Subject: R/116/19/DOC

Juan Baeza Area Team Leader – Planning Department, Arun District Council | Location: First Floor, Arun Civic Centre, Maltravers Road, Littlehampton, BN17 5LF

RPCH/119A

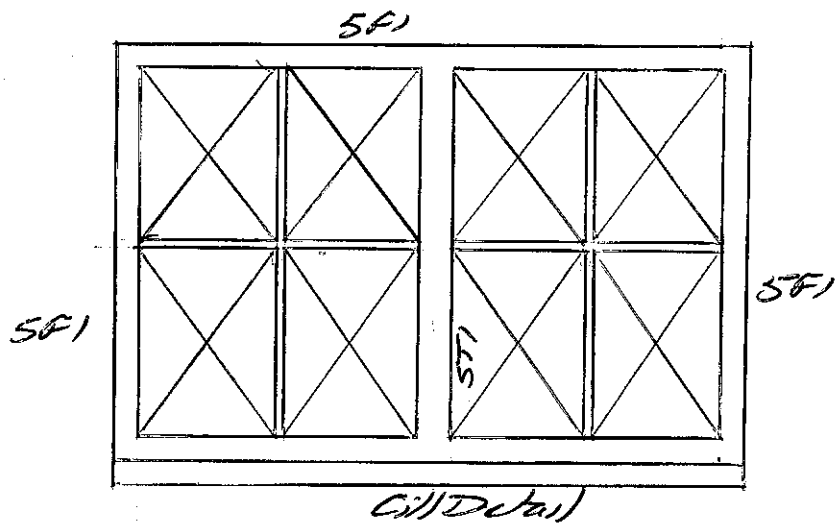
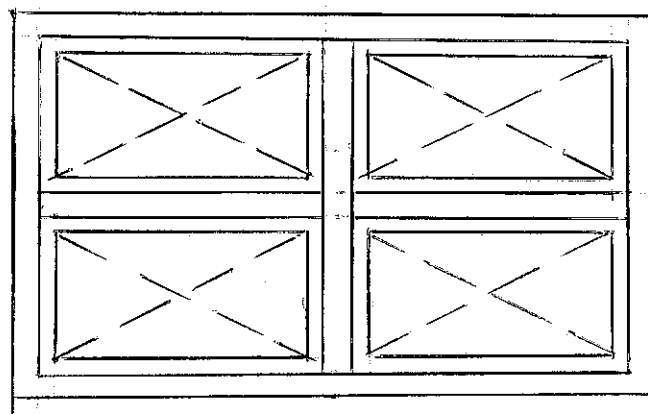
I am unable to discharge this condition as the plans you have submitted do not appear to be in the scale required by the condition applied by the Inspector that is "Details shall include elevations at not less than 1:20 showing opening arrangements and division of fixed and opening casements or sashes, and details at not less than 1:2 of all frame, cill and head sections and sections through casements or sashes, making clear the glazing method and thickness of sealed double glazing units."
